# **Annex 1 to Submission by North Somerset Council in respect of Action point 19 ISH 5 -Environmental matters**

## **March 2021**

Following receipt of the cross-sectional details of the proposed Trinity footbridge North Somerset Council as Local Planning Authority considers that in relation to the impacts of overbearing impact and adverse visual impact these may be slightly less severe than we had feared previously

Figure 10: 21st September 12pm

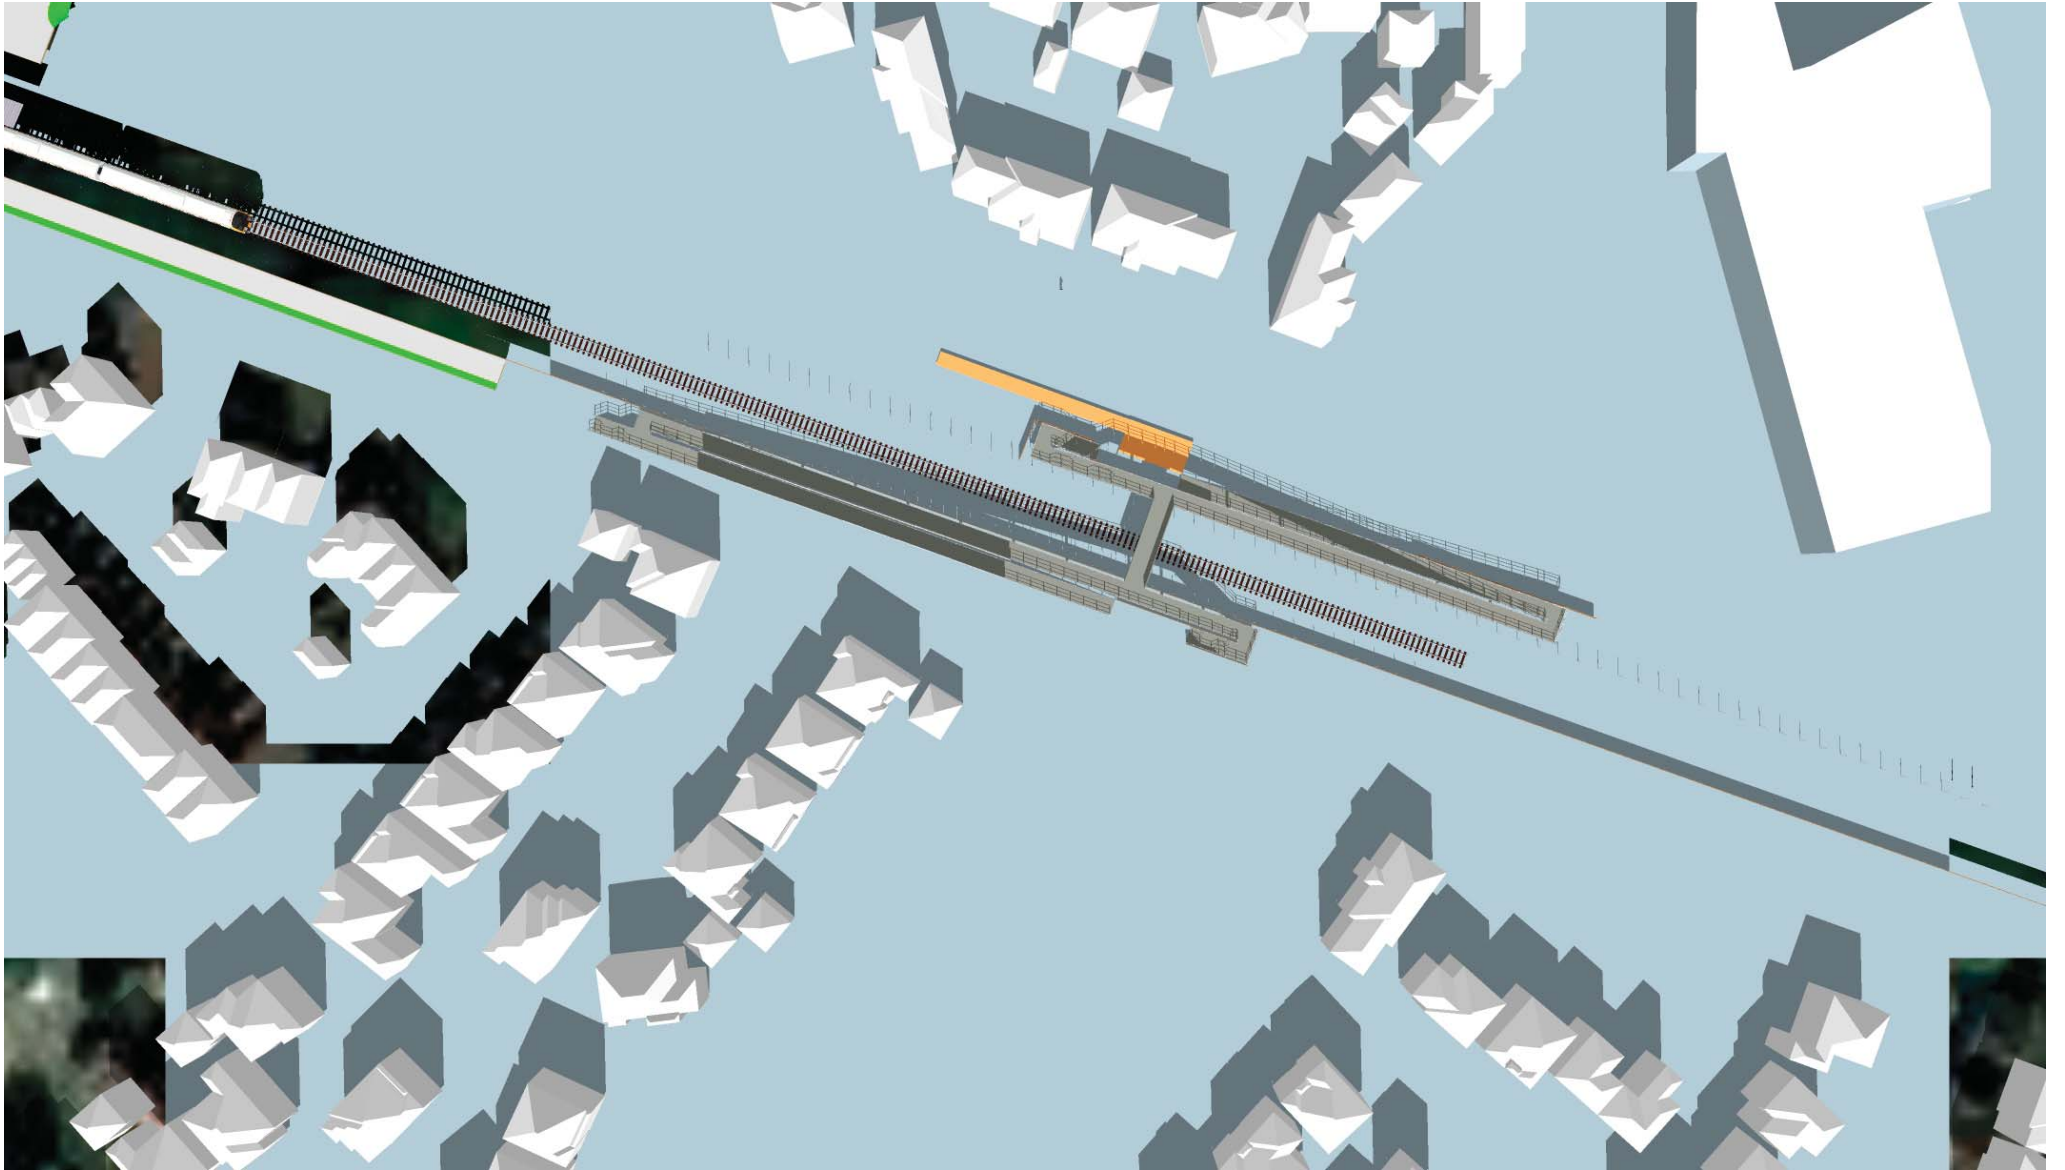
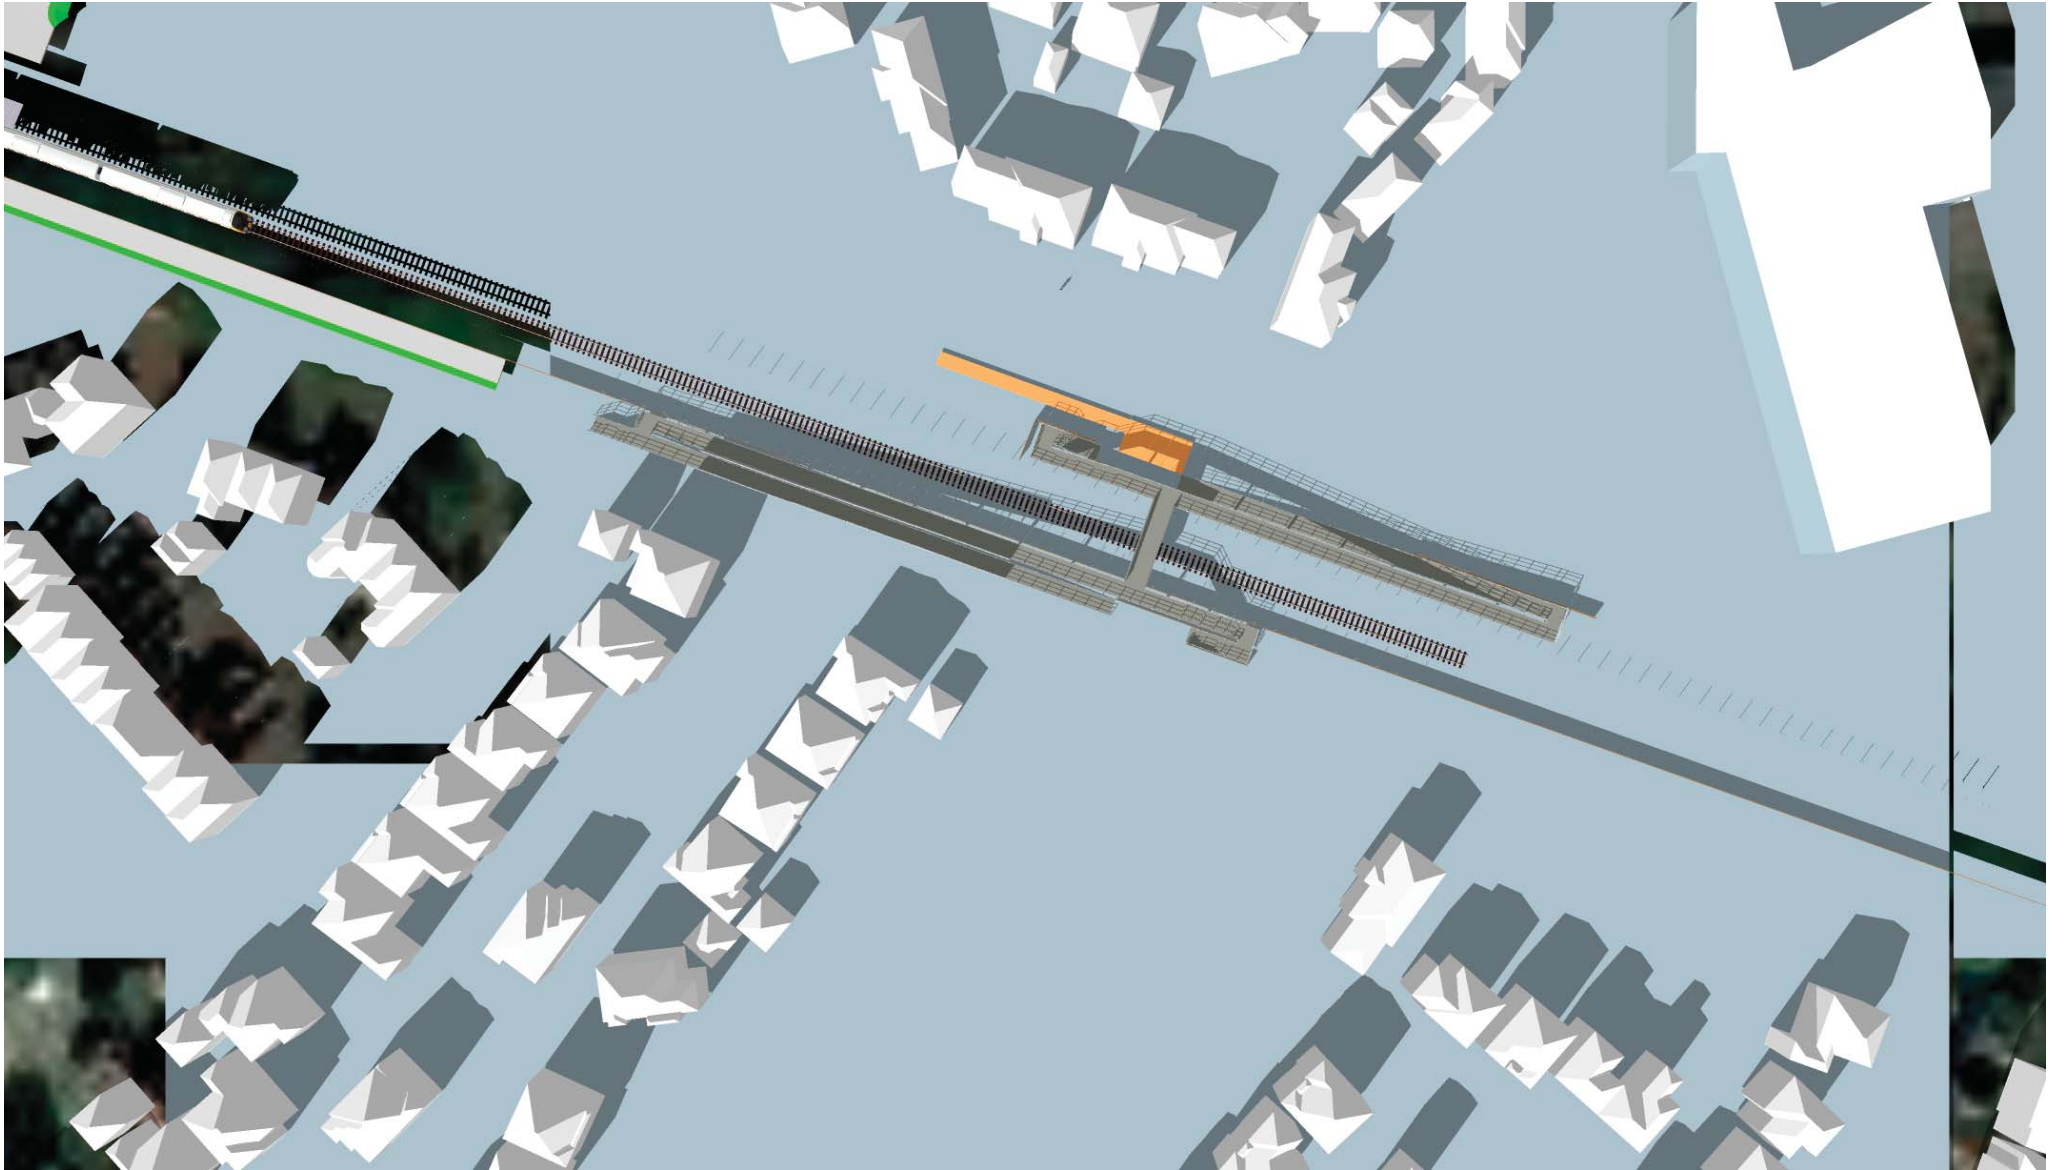
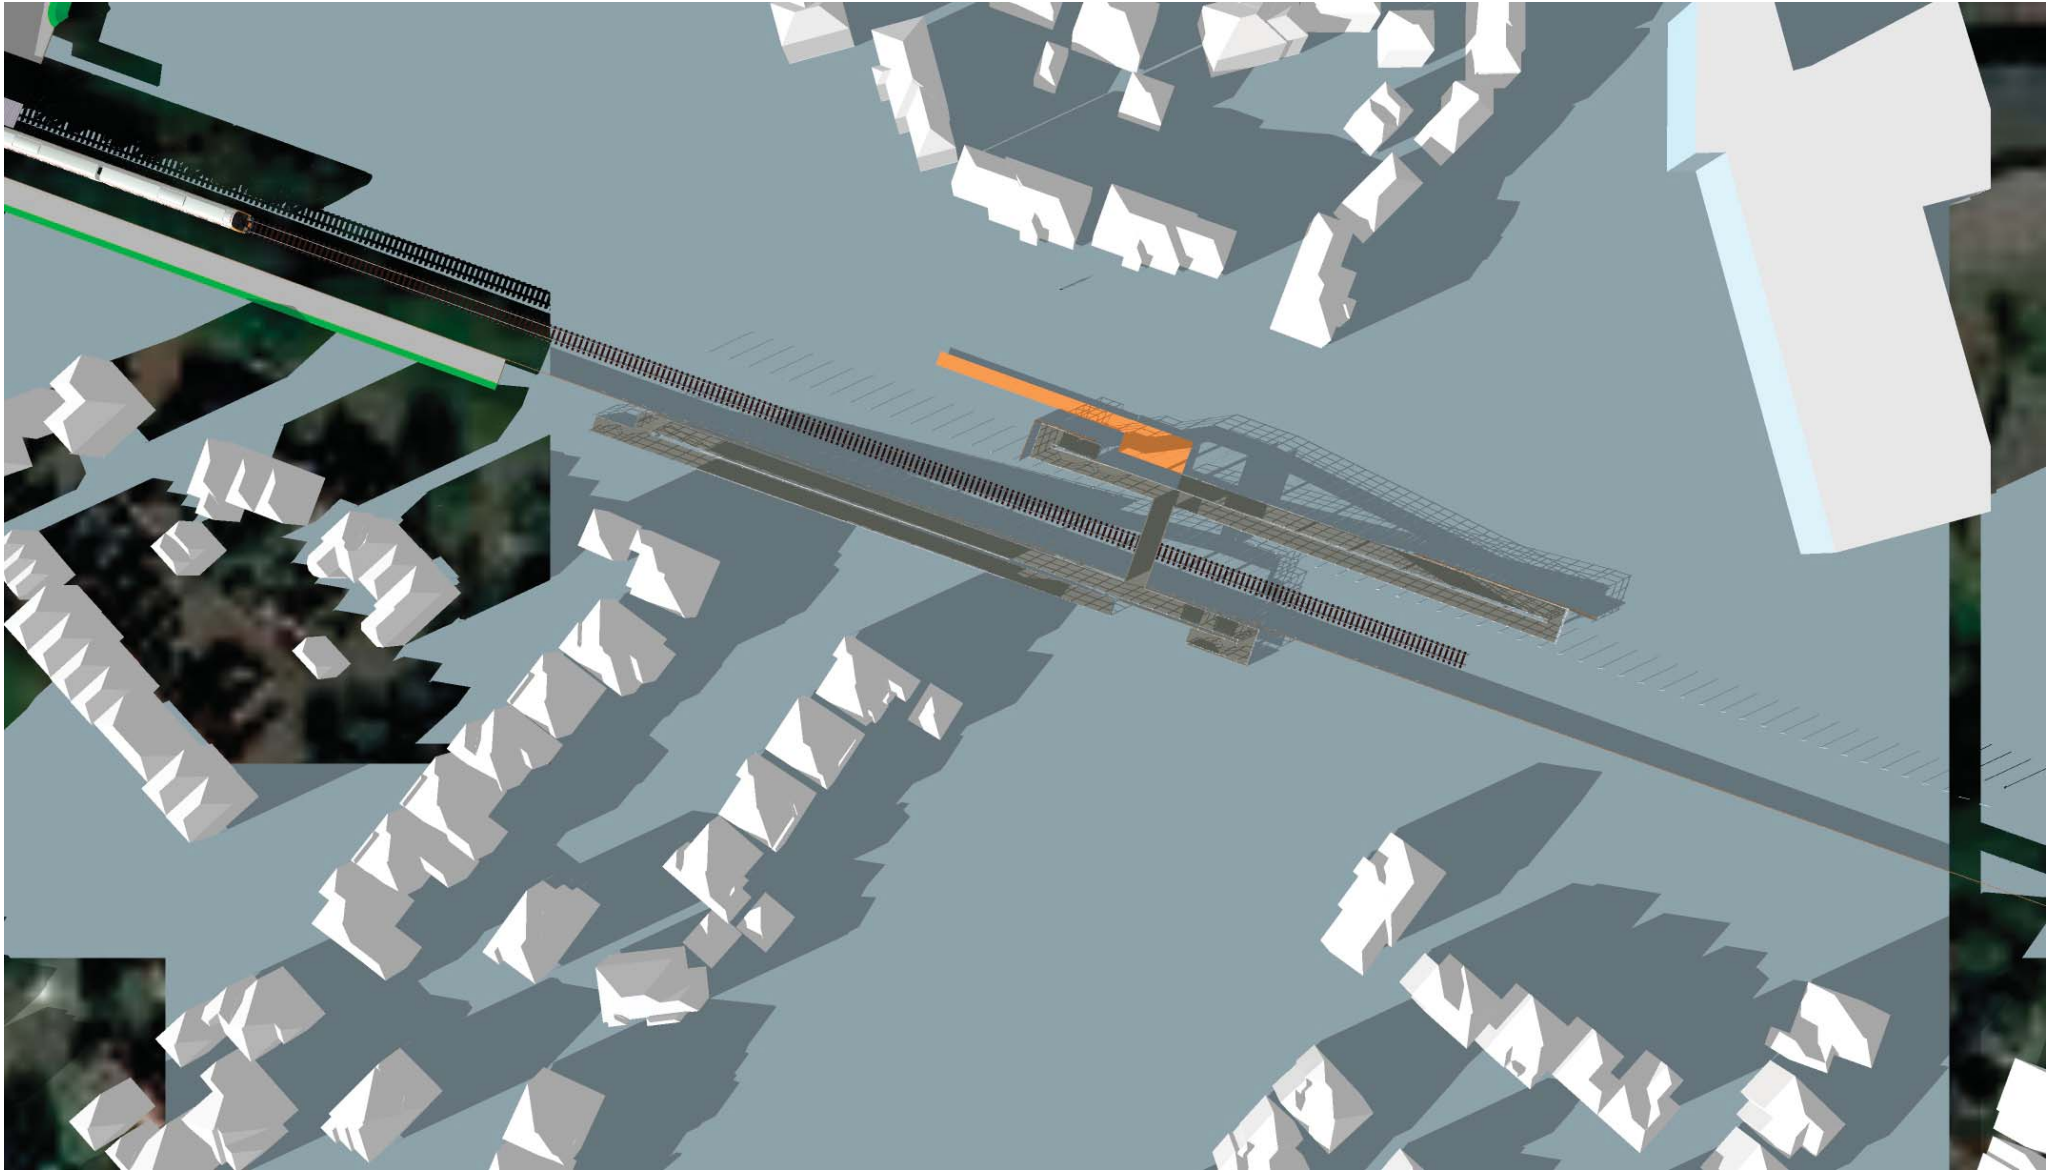
Following receipt of the shadow diagrams it is now easier to assess the impacts that these structures will have on surrounding properties.

The study presents shade impact graphics at 10:00am, 12:00am, 2:00pm and 4:00pm during Spring Equinox, Summer Solstice, Autumn Equinox and Winter Solstice. We consider that this provides sufficient information. From this information, it appears that the footbridge structures have the *potential* to overshadow properties along Tansy Lane (No 9, 11, 15 in particular) rather than properties to the south of the bridge.

From these graphics, it appears that these structures would have no impact at most times and periods of the year on these properties, except for the Winter Solstice
